**Re: Rio Grande Zoological Park Entry,
Request for Permanent C.O. - Approved
Engineer's Stamp dated: 11-09-10 (K-13/D034C)
Certification dated: 10-24-11**

Re: City Zoo Entry
Grading and Drainage Plan
Engineer's Stamp dated 11-09-10 (K13/D034C)

RE: Rio Grande Zoo Entry (K13/ D34C)

Re: City Zoo Entry
Grading and Drainage Plan
Engineer's Stamp dated 11-02-10 (K13/D034C)

LEGAL DESCRIPTION: RIO GRANDE ZOO.

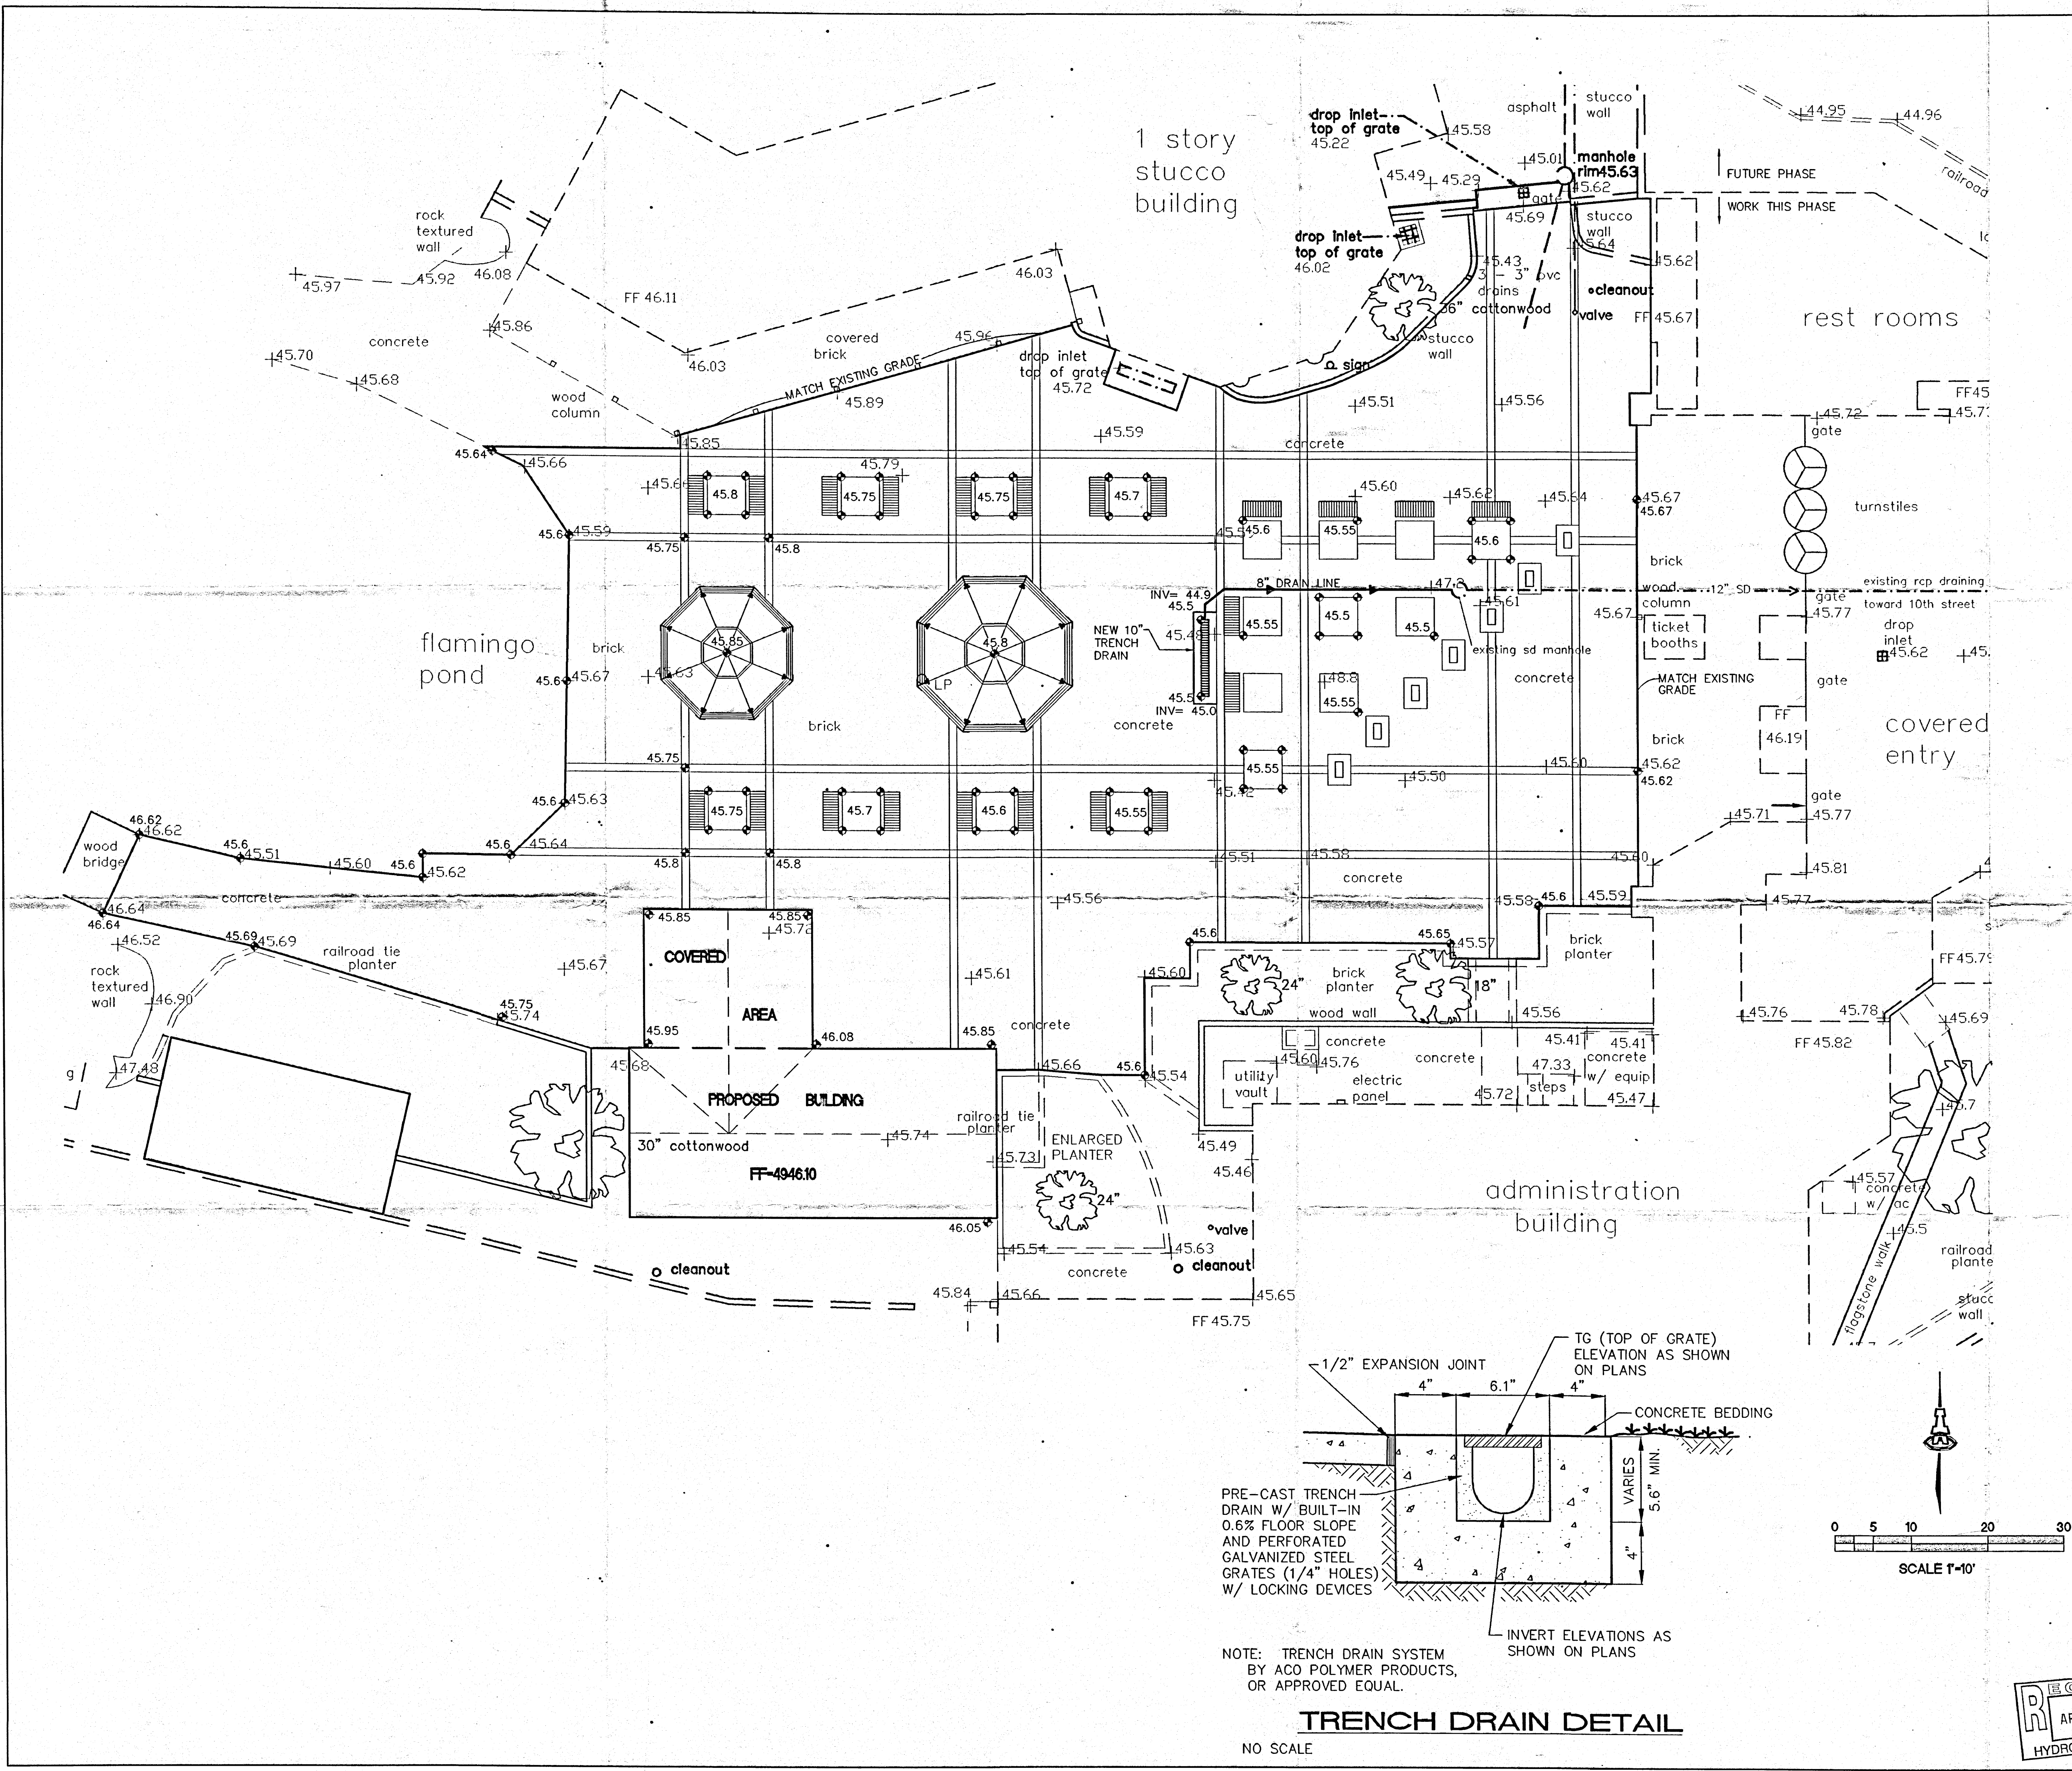
- Provide drainage calculations and directional Flows.
- The discharge line through the back of the inlet requires an SO 19 permit.
- Provide a narrative of this site. What is the flood zone, etc.?
- Is this existing pavement, repaved or new pavement?
- What is the hatched area in the N.E. corner?
- Landscaped areas between curbs should be depressed.

Drainage calculations, directional flow arrows, and a narrative have been added to the plan. The standard right-of-way construction notes for an SO 19 have been added. All of the parking lot paving shown is existing. The sidewalk culverts shown along the west side of 10th Street are also existing. All parking lot medians are existing and have mature landscaping. The curb cuts proposed are located in areas where the landscaping can be depressed and not negatively impact the landscaping.
